**CONDITIONS OF APPROVAL - Project # PR-2025-011387/SI-2025-00040 - Site Plan-EPC**

The purpose of this letter is to demonstrate how the Site Plan-EPC for Savio Ridge was revised to meet the Environmental Planning Commission's (EPC) conditions of approval per the hearing held on March 20, 2025 (Project # PR-2025-011387/SI-2025-00040).

Sheet No.  
LP-1.0 2 of 12

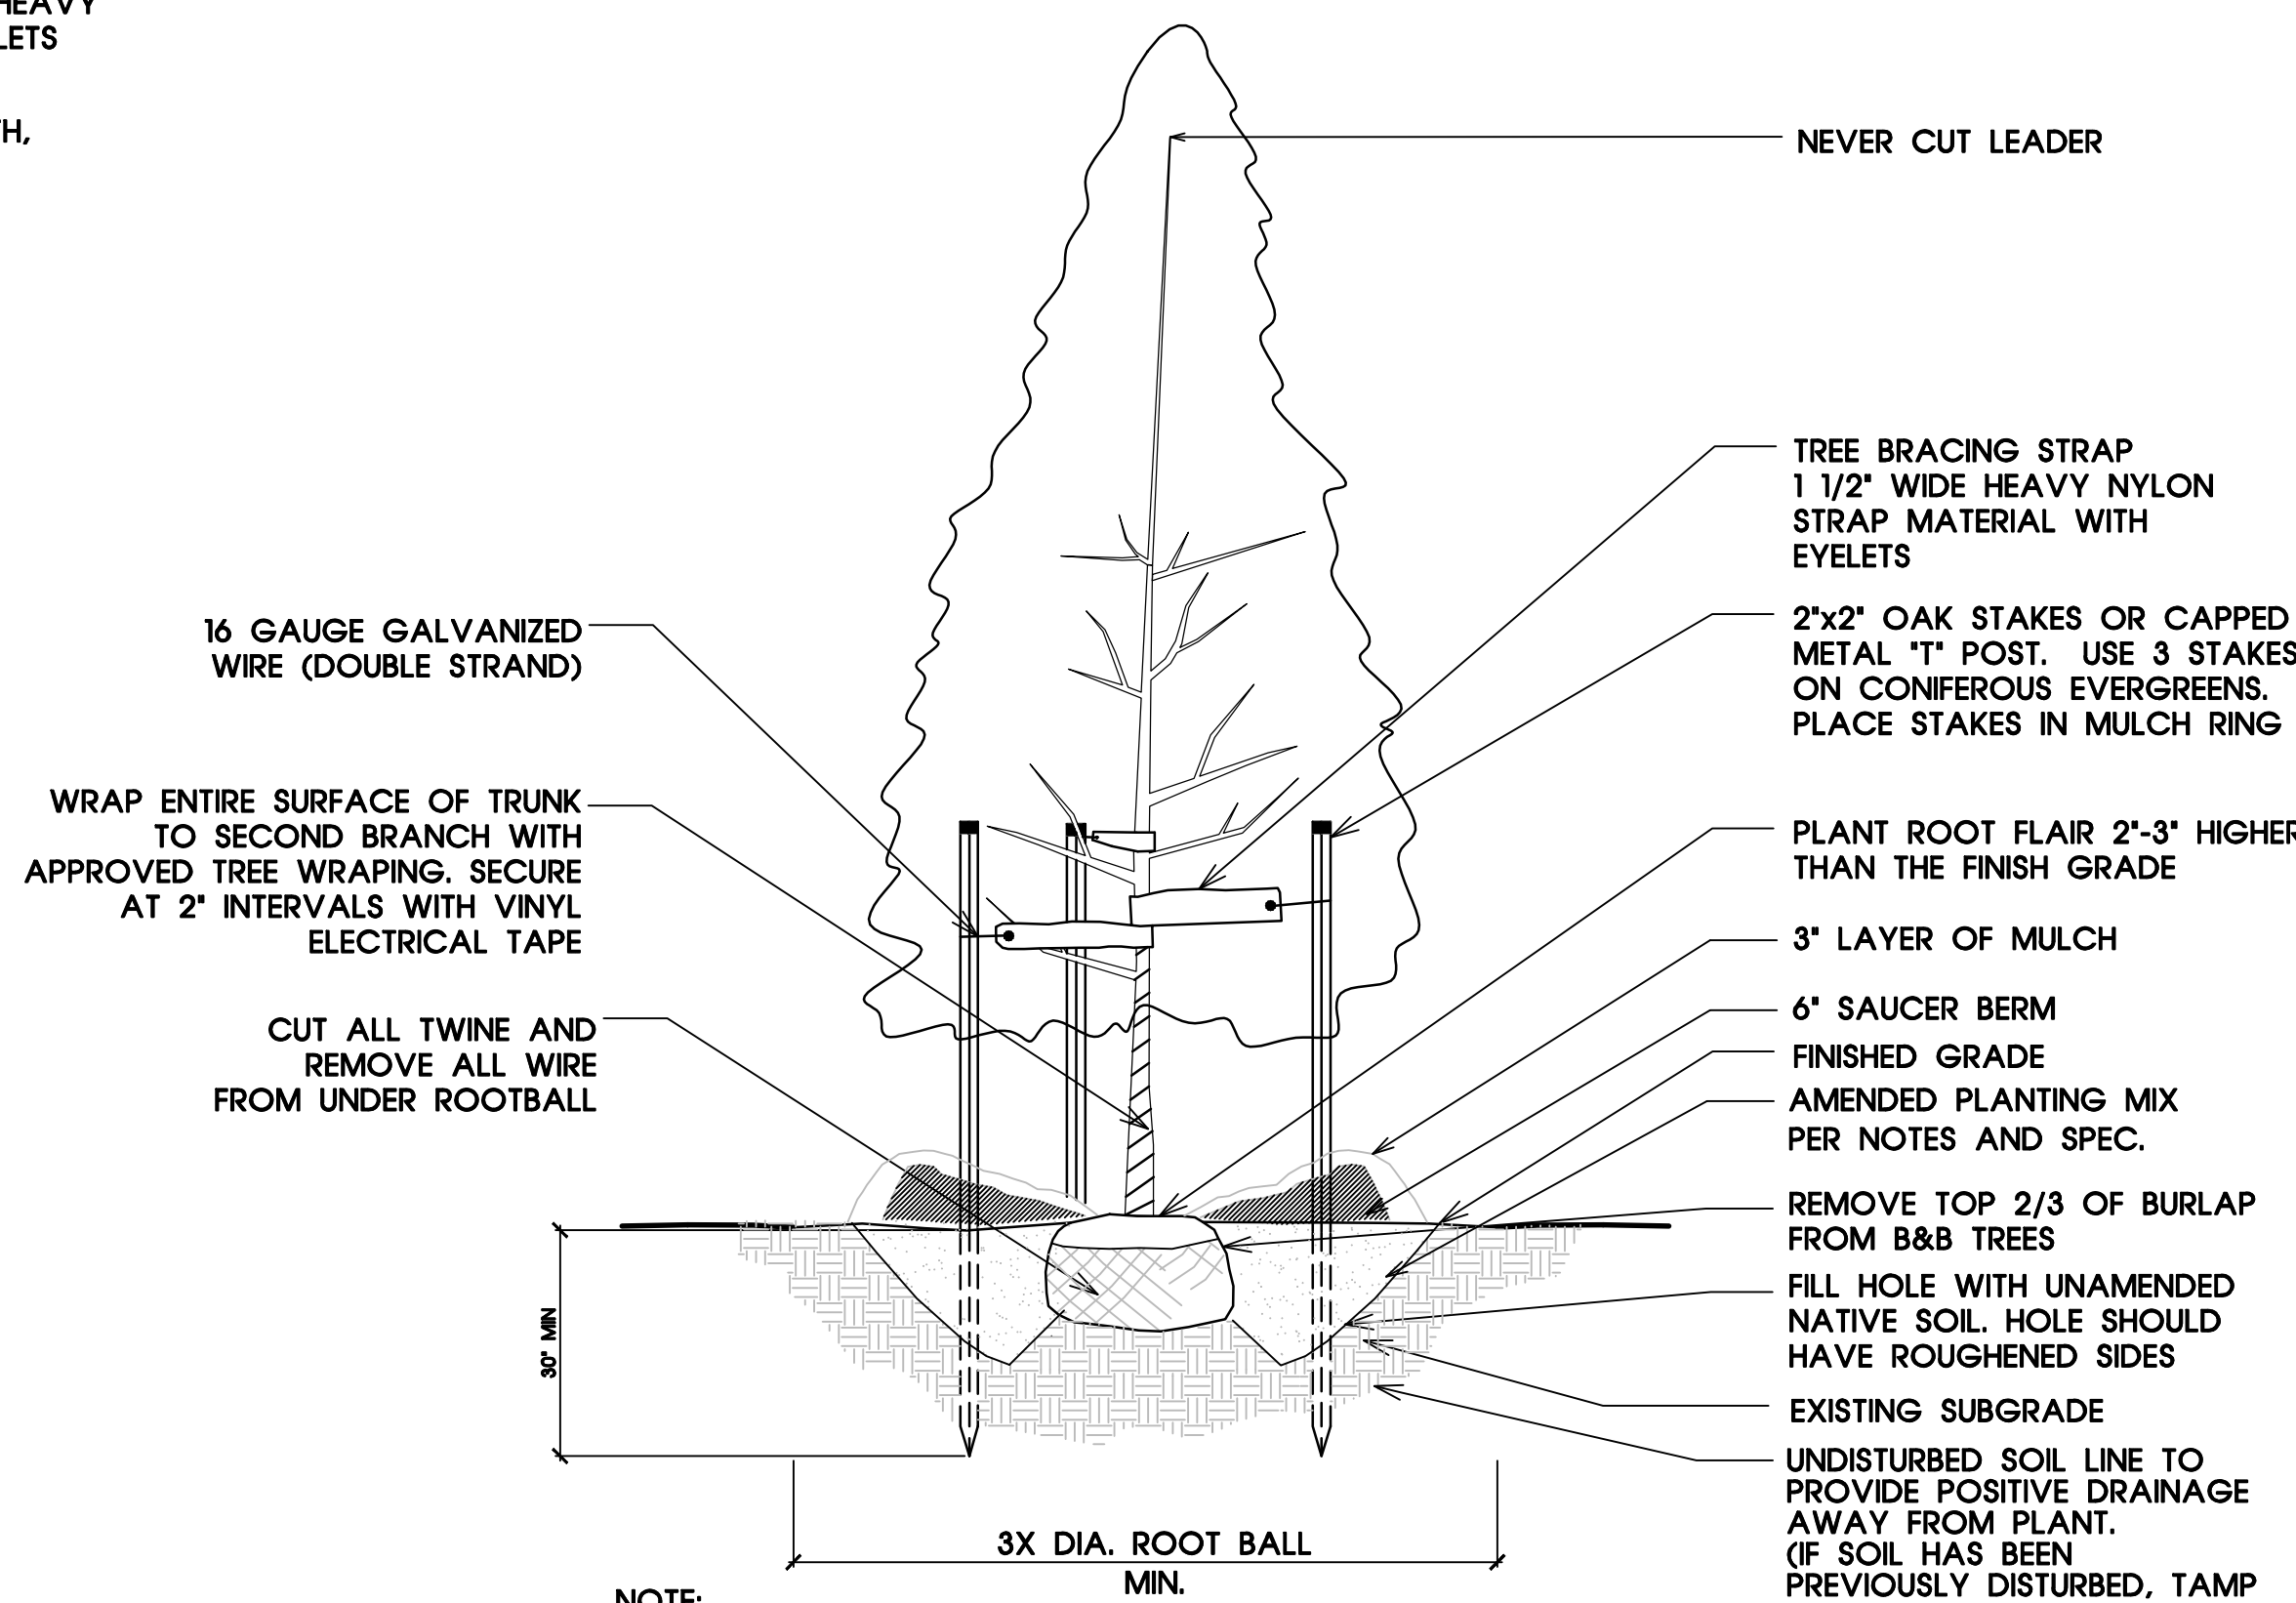
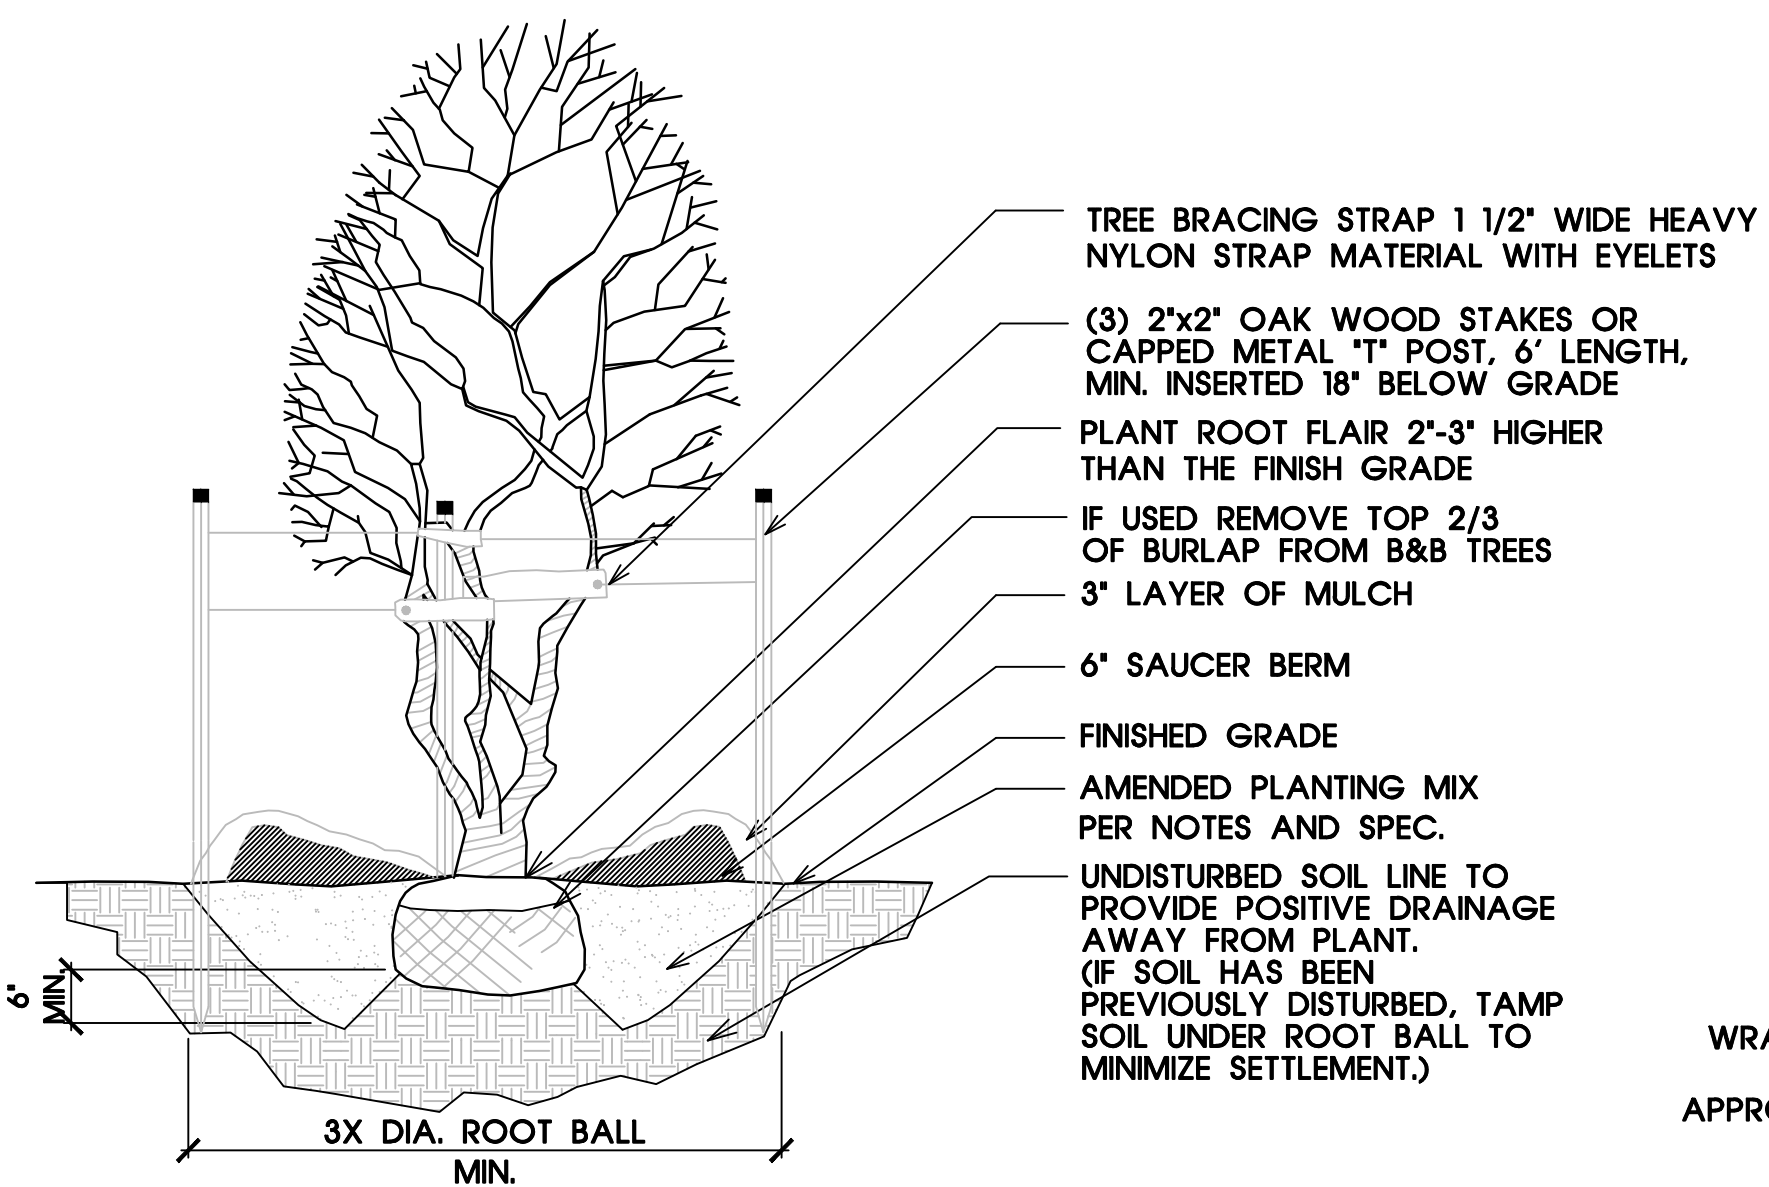
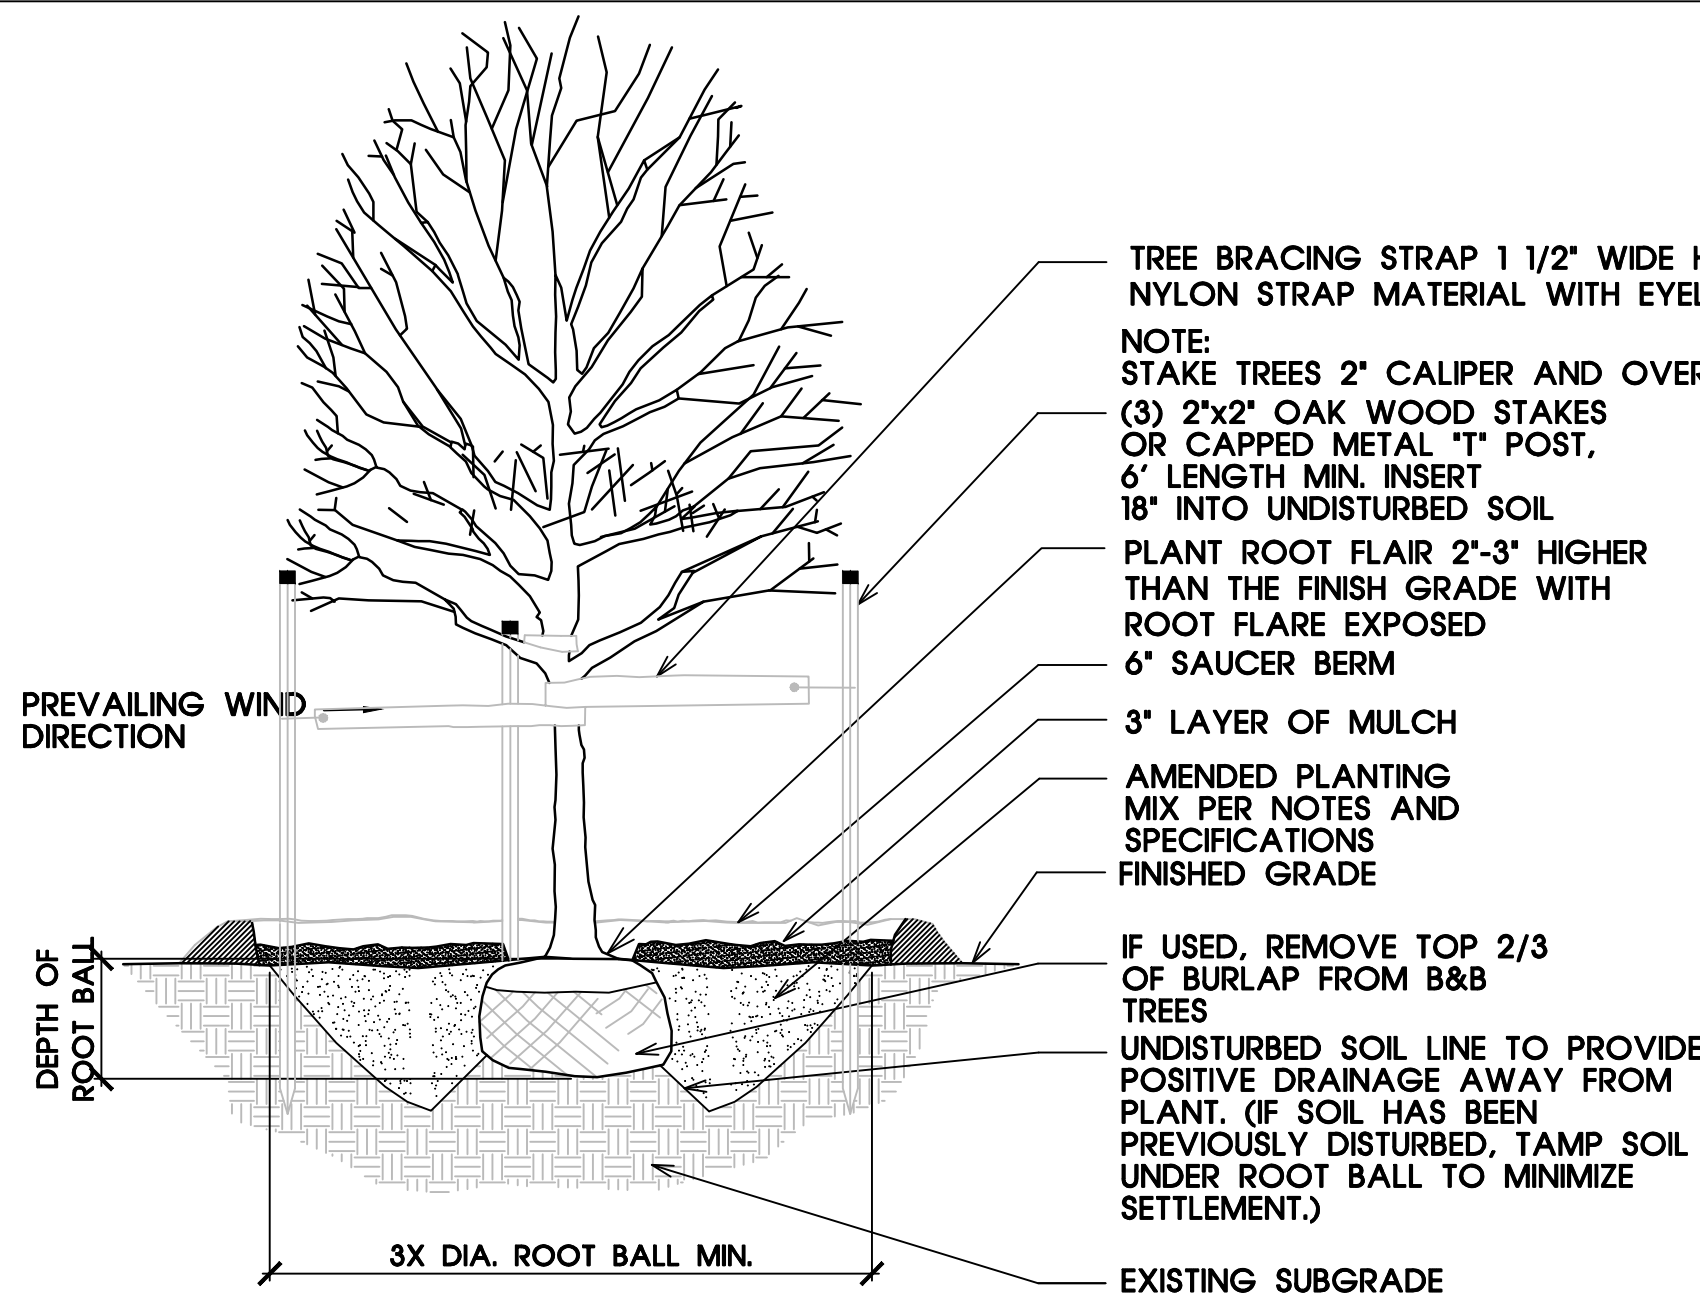
- b. The site plan references a pocket park and the landscape plan references a neighborhood park. The sheets shall be updated to match.

*Applicant Response: The Landscape Plan has been updated to label the "Pocket Park". See sheet LP-1.0.*
